Redlines to correct error in mapping.

Chris Owen
10/2/2018

8. Existing and Proposed Lot Information

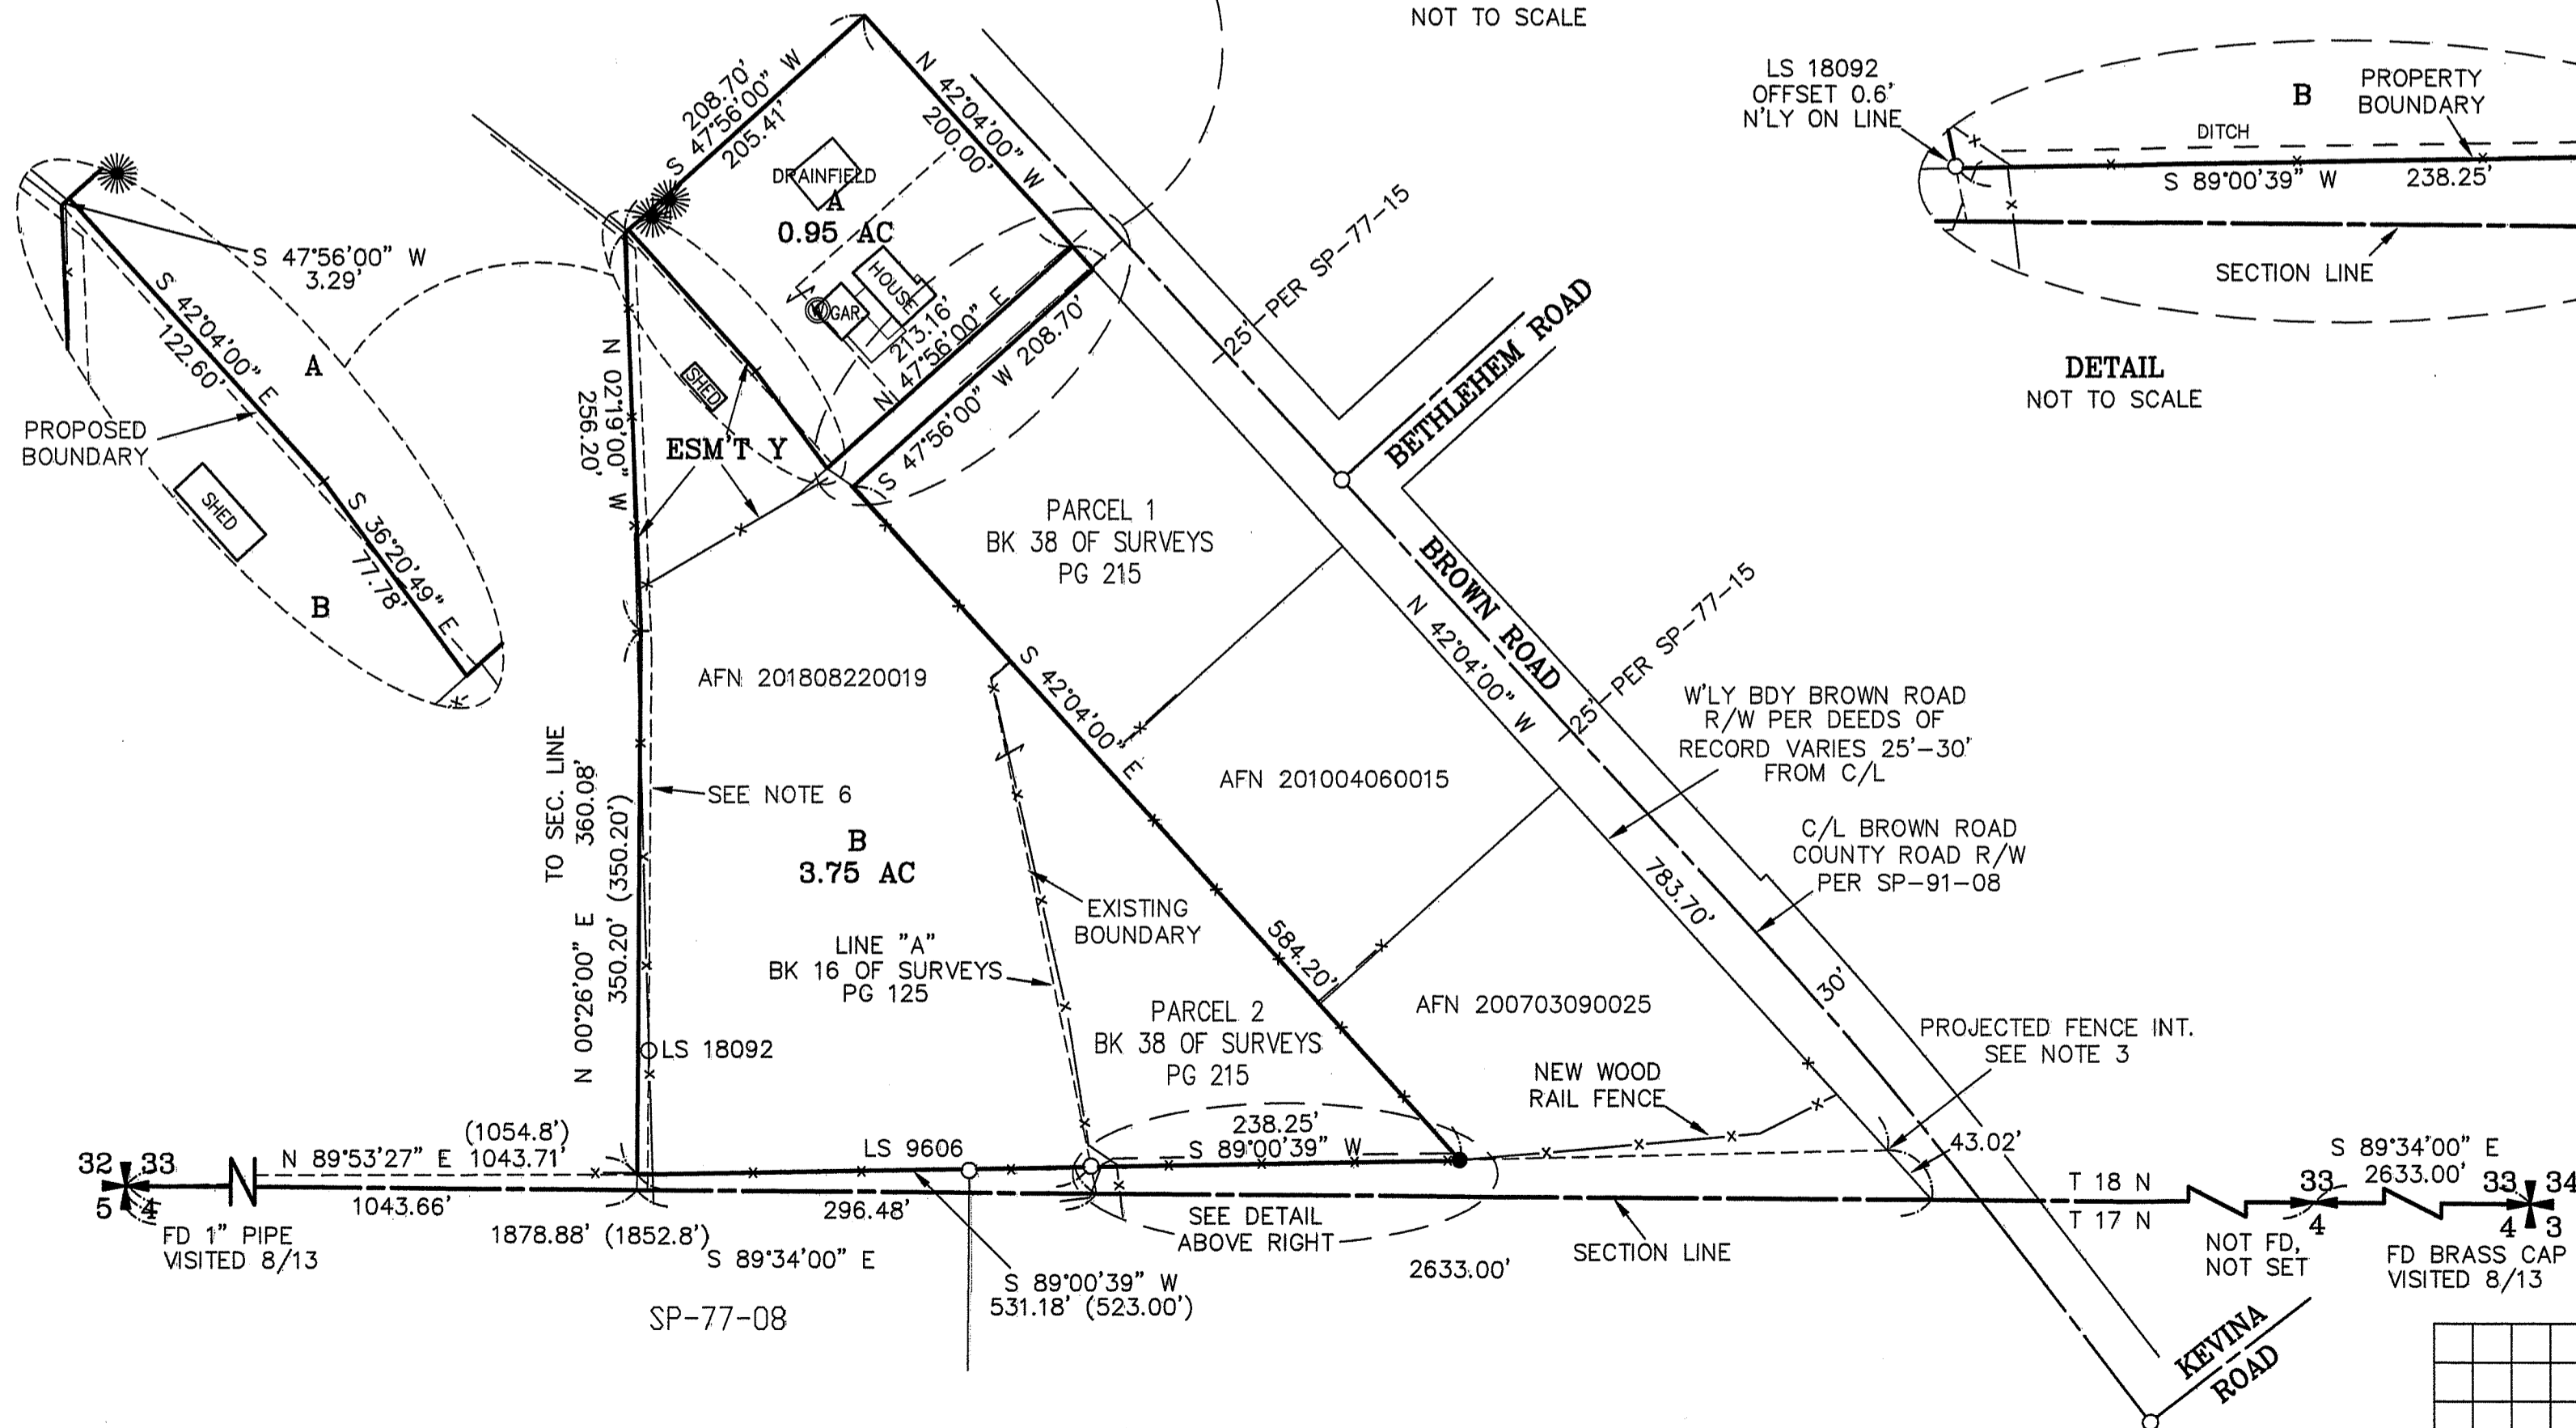
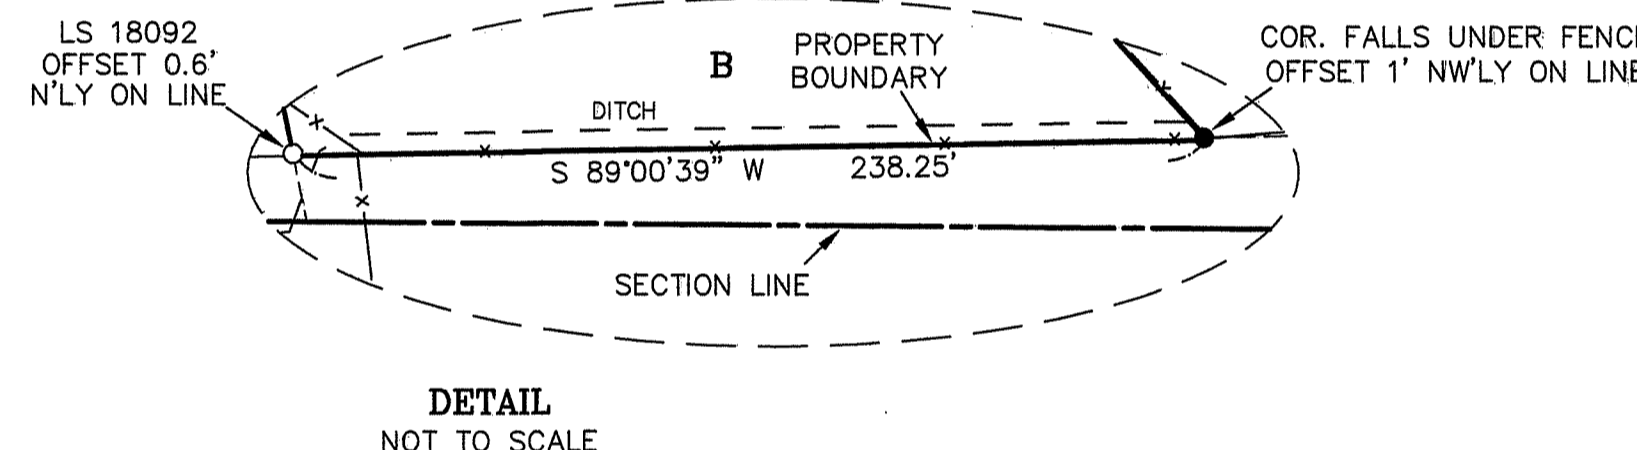
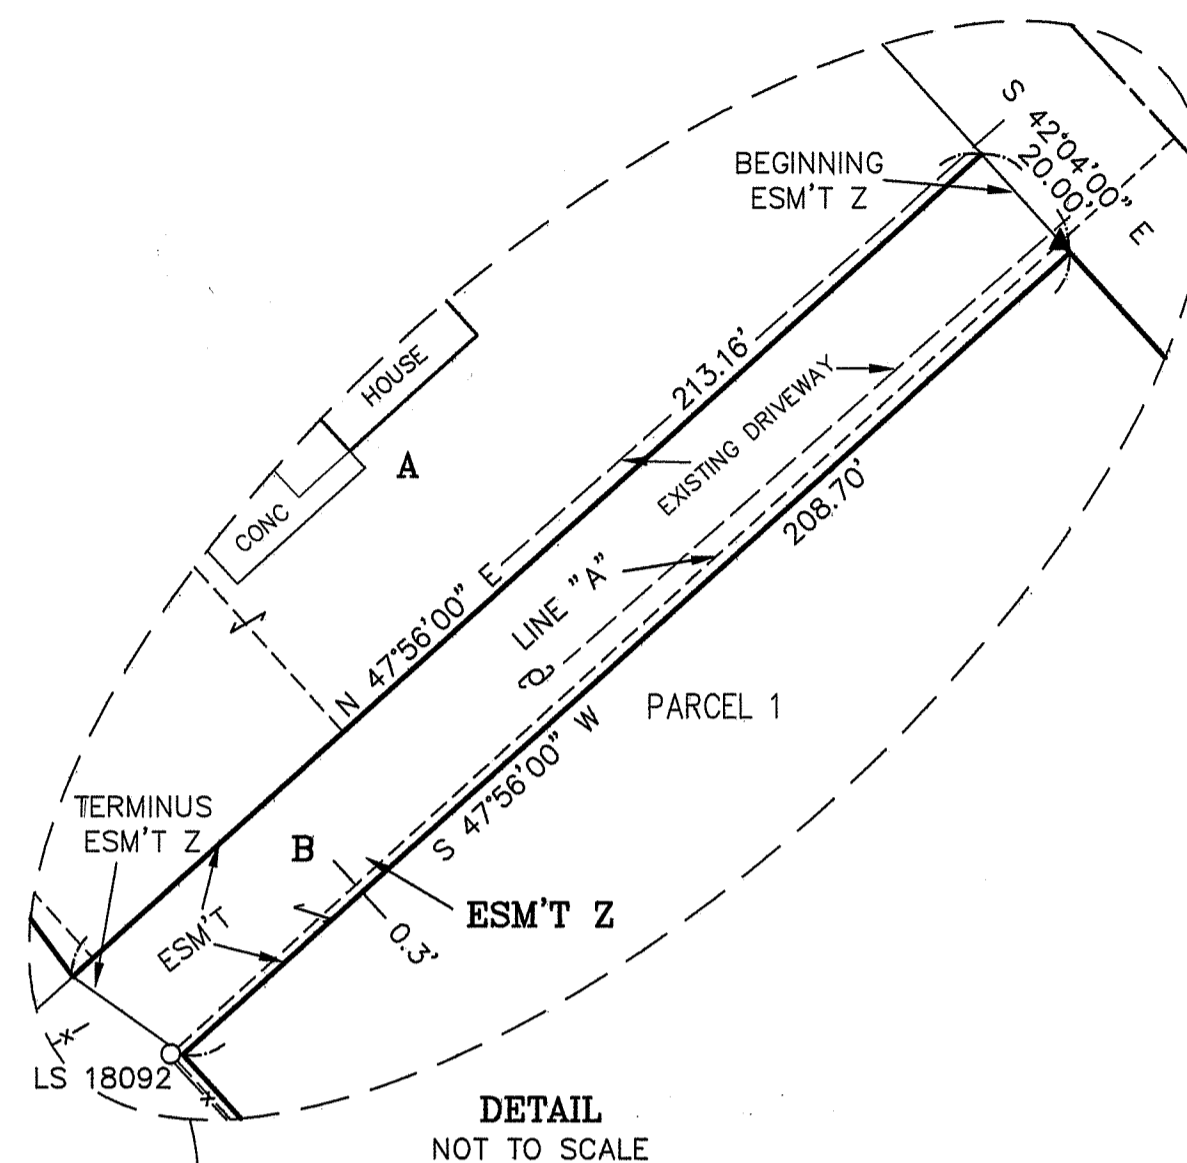
3.40 AC 3.75 ~~3.64~~ AC
